Application No: BR/307/20/PL
Site Address: Butlins Upper Bognor Road Bognor Regis PO21 1JJ
Description of works: New reception kiosk and alterations to car park layout. This application is in CIL Zone 4 zero rated as other development.

Thank you for your internet representation made on 12th January 2021 which has been recorded as an objection with the comments as follows:

Bognor Car Park Works Proposed Site Plan

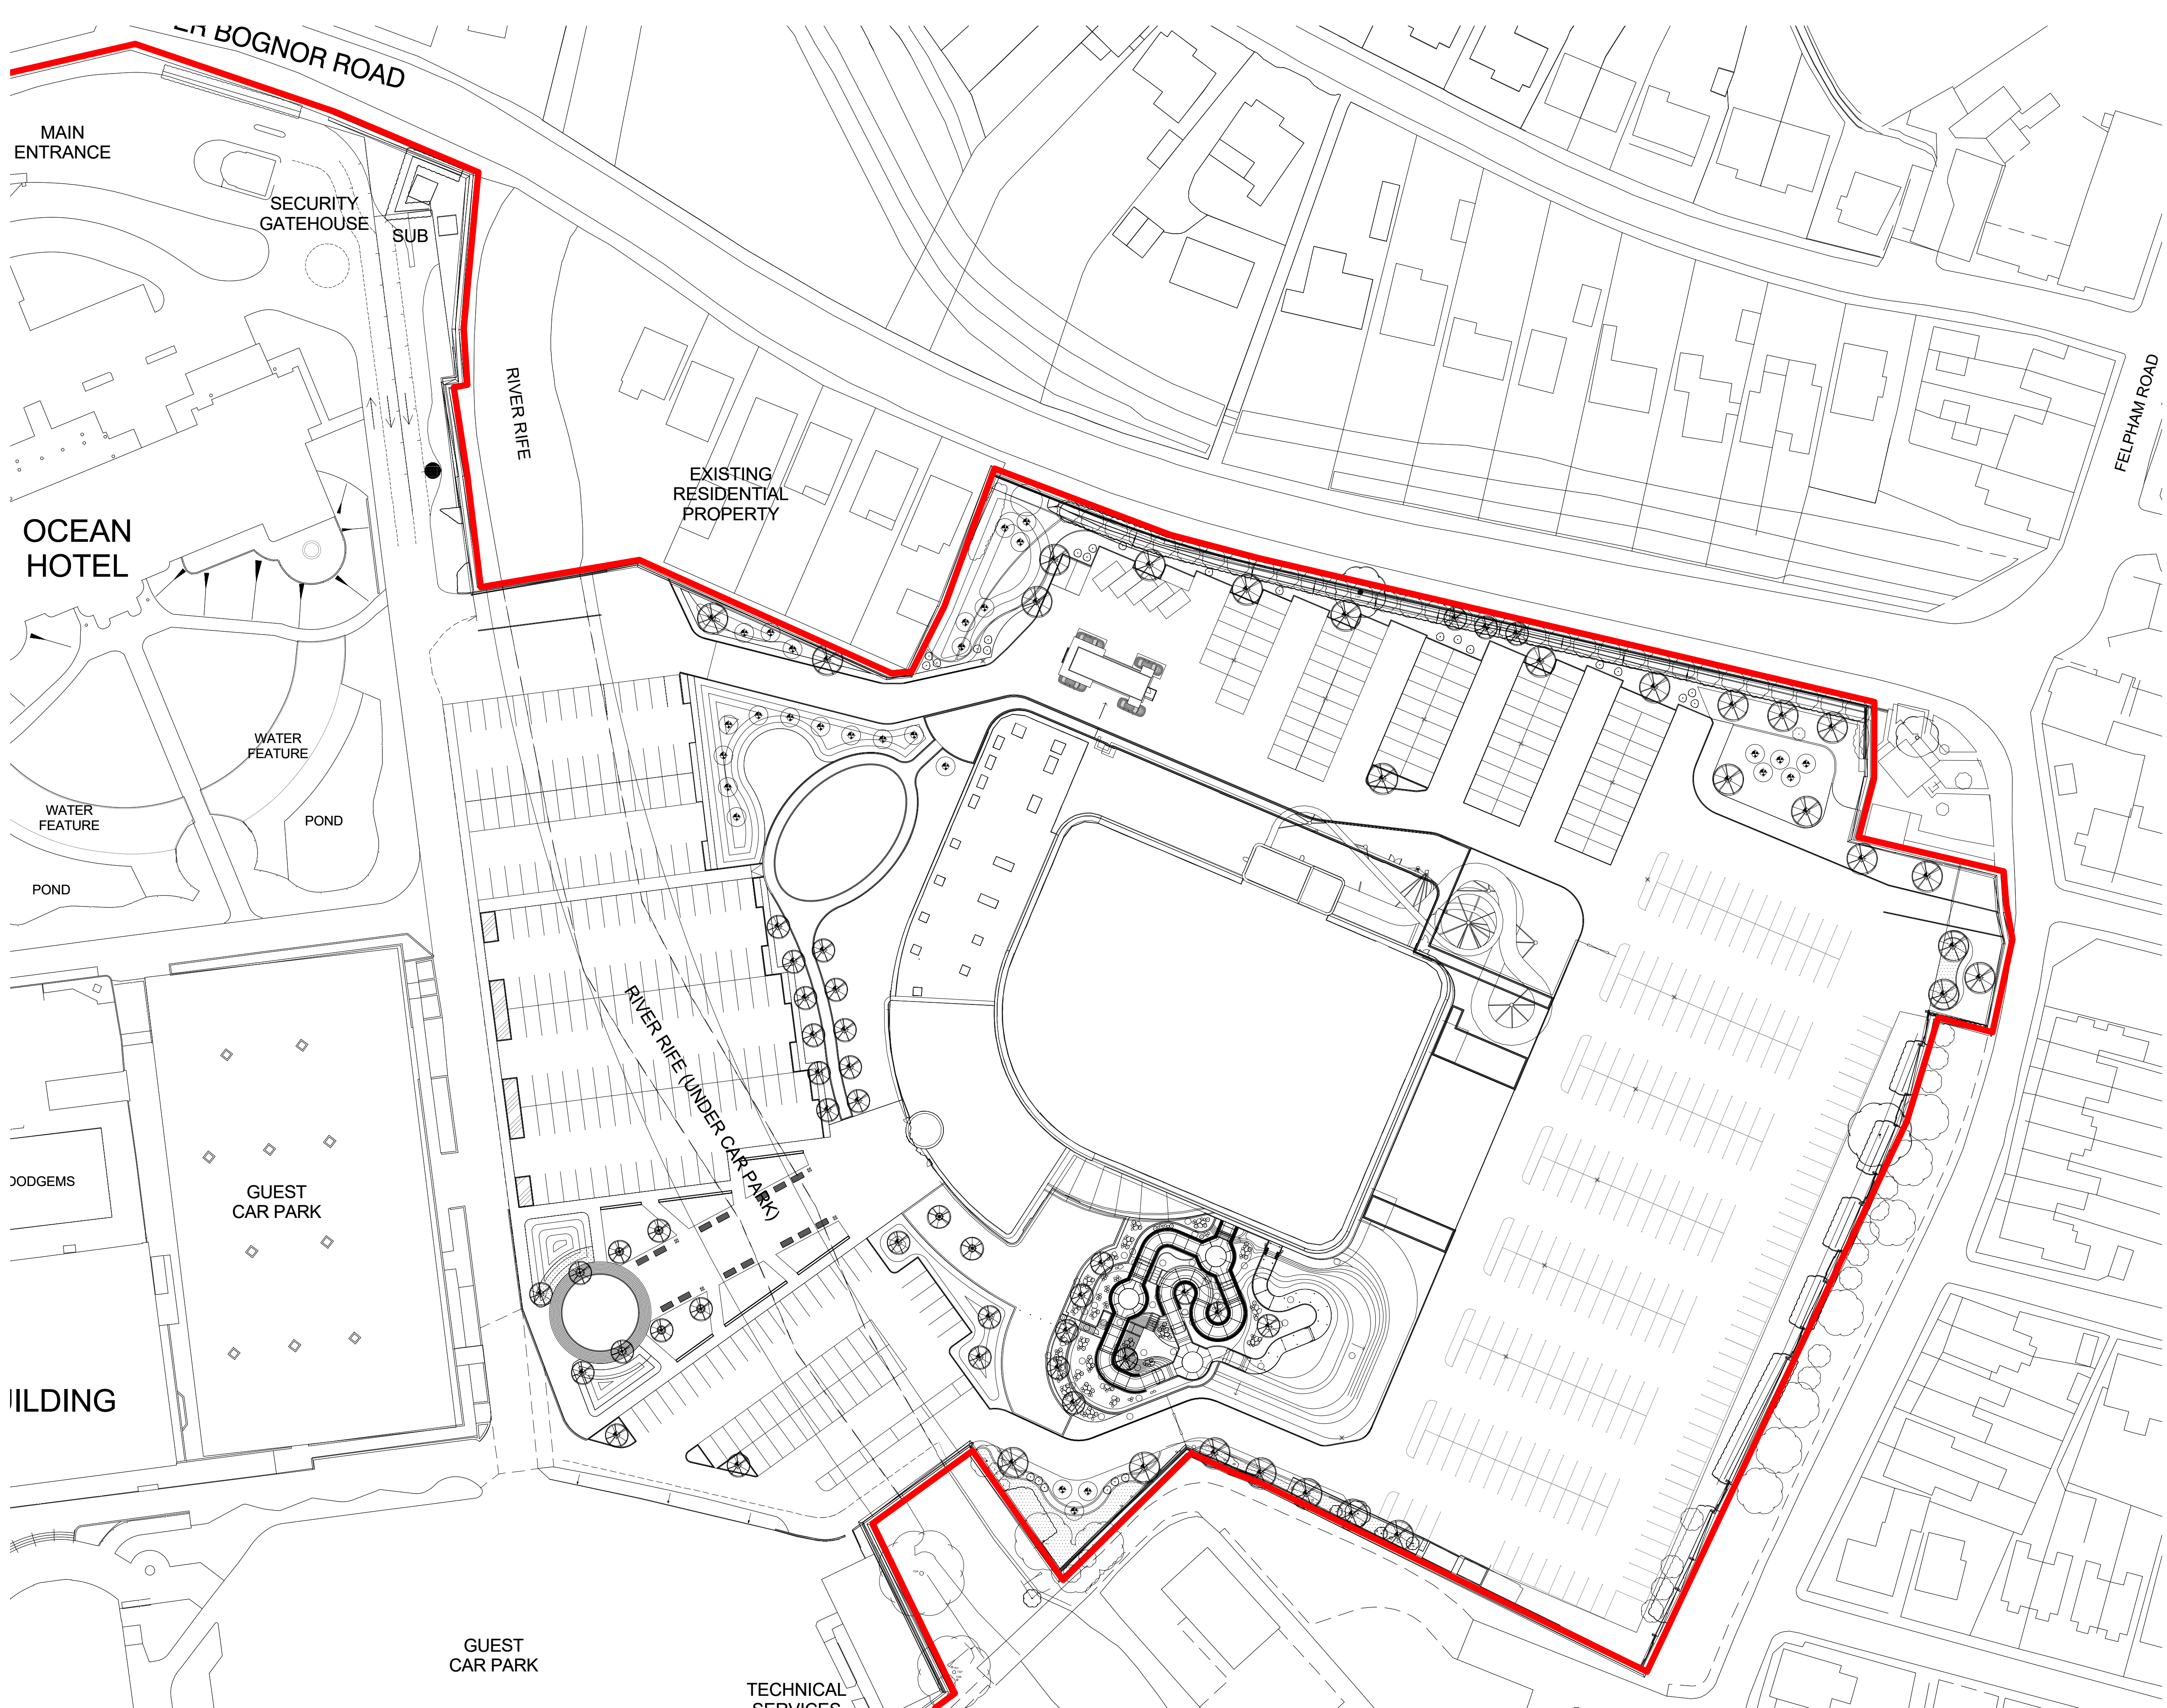
The proposed stacking of the cars (and they will be stacking) will now be directly behind my garden and the other gardens of the residents in the Upper Bognor road bungalows instead of near the entrance where only Butlins hotel guests will be affected by the extra noise and pollution of the stacked cars/vans etc exhausts and waiting guests. When the cars are stacking they will have music blasting from the cars like they currently do when waiting to enter Butlins and shouting which will now be just metres from my property. We already have horrendous noise from the stupidly located fairground and with the new routing of the road and stacking of cars, this will cause an additional noise nuisance. We will also now be exposed to the extra pollution from the exhausts of the waiting vehicles to which my son who is asthmatic will suffer greatly. I have older neighbours who will also now have to breath the extra pollution from the stacking of the cars / vans / lorries etc which will affect there health too. Butlins have a very poor record of noise control and any policy put forward by them to limit noise and pollution will fail, you only have to look at their record of creating noise pollution to see that any measure they take will fail. They are reactive and not proactive, this is demonstrably true historically. This new road layout will ruin the lives even further of the residents in that area which is already affected by horrendous noise pollution from the fairground and circus tent when it arrives.
